From: Fiona Fitzgerald
Sent: 04 December 2018 12:36
To: Planning.Responses
Cc: Richard Castro-Parker
Subject: LU/286/18/PD

Environmental Health would strongly recommend **refusal** for this application. This is for the reasons noted below:

GROUND FLOOR PLAN

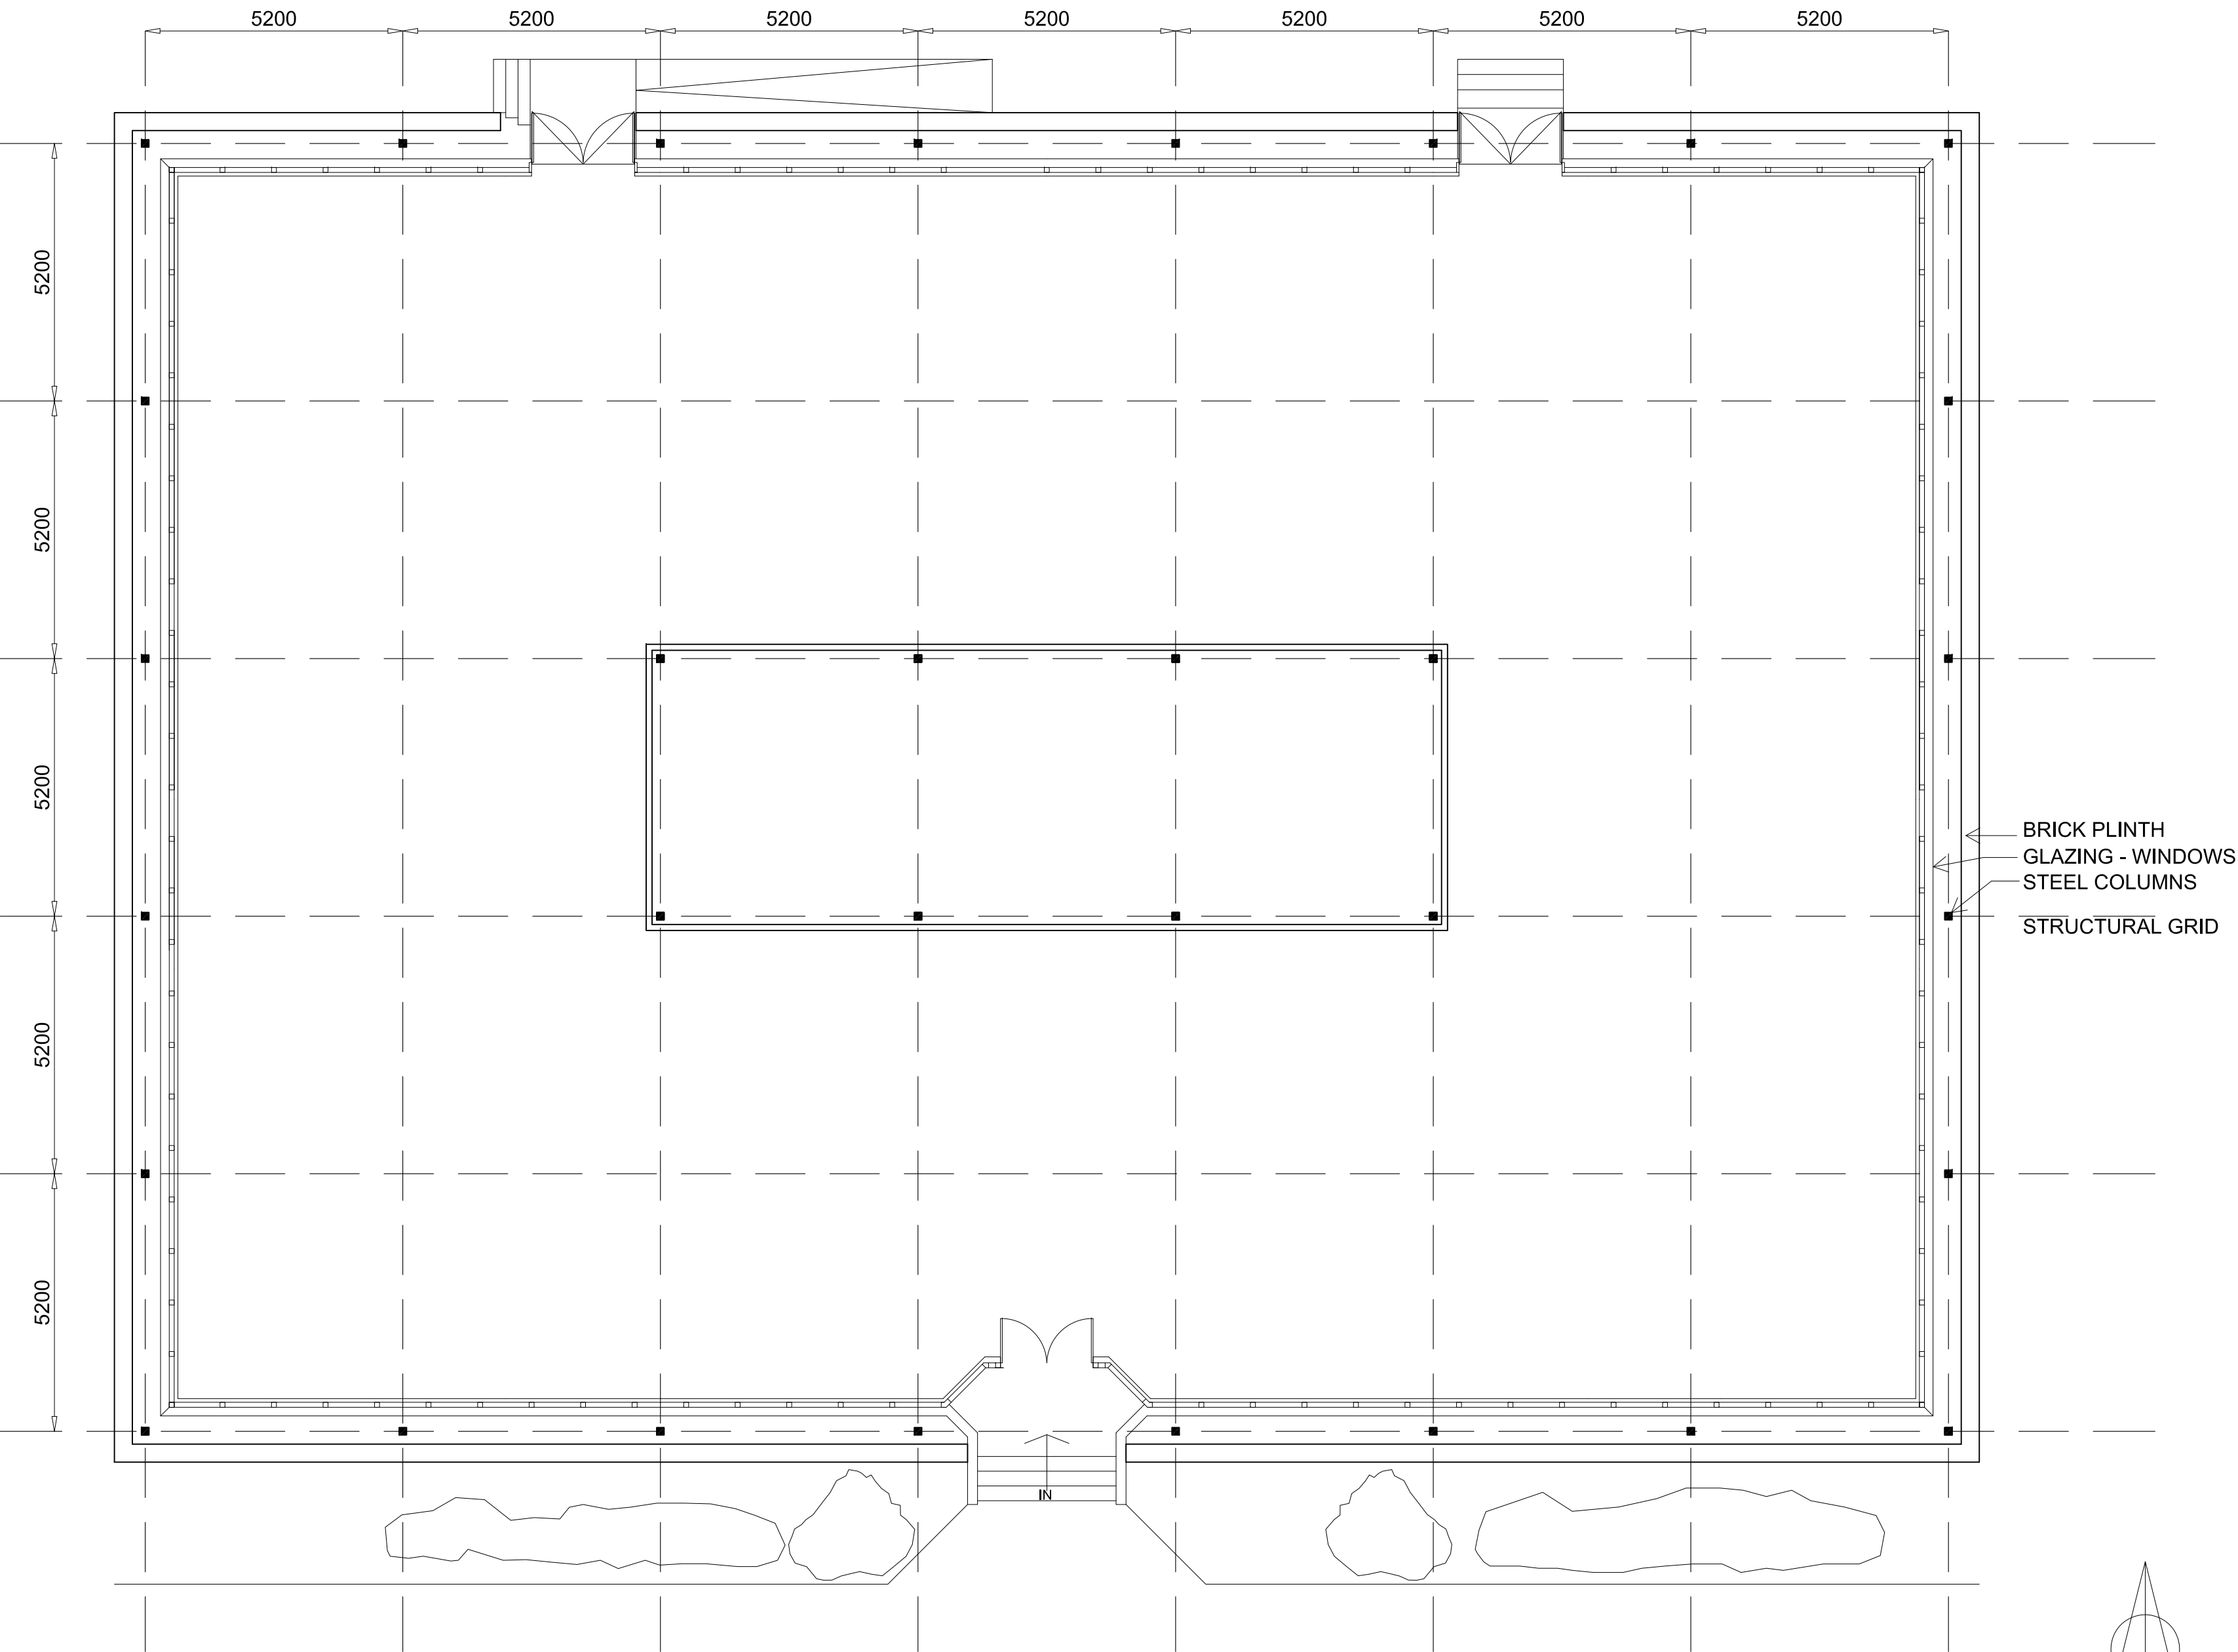
- Rooms need to be of a useable and practicable size to enable appropriate furniture or appliances to be fitted and used safely.
- Whilst there are no specific minimum sizes for bathrooms a number of the ensuite facilities appear to be narrow and would potentially make practical use very restrictive.

- The studio flats located internally with in the building, do not have any windows, velux windows as the only source of light, ventilation should be avoided where possible. All velux/ ceiling/roof windows must be able to be fully opened for ventilation during spells of prolonged and heavy rain or snow without allowing it to enter the room. Each velux window must also have integral passive ventilation for ventilation even when the window is shut. The Housing Health and Safety Rating System (HHSRS) states as a relevant matter that there should be a "reasonable view out of all rooms, other than those where privacy is required, such as bathrooms and WCs", as this can have a negative effect on the mental health of the occupants, especially over the longer-term. Each scenario will be assessed on a case-by case basis by an Officer to ascertain whether the windows are suitable and/or appropriate. In instances where it is not considered suitable alternative windows may be required to be installed.
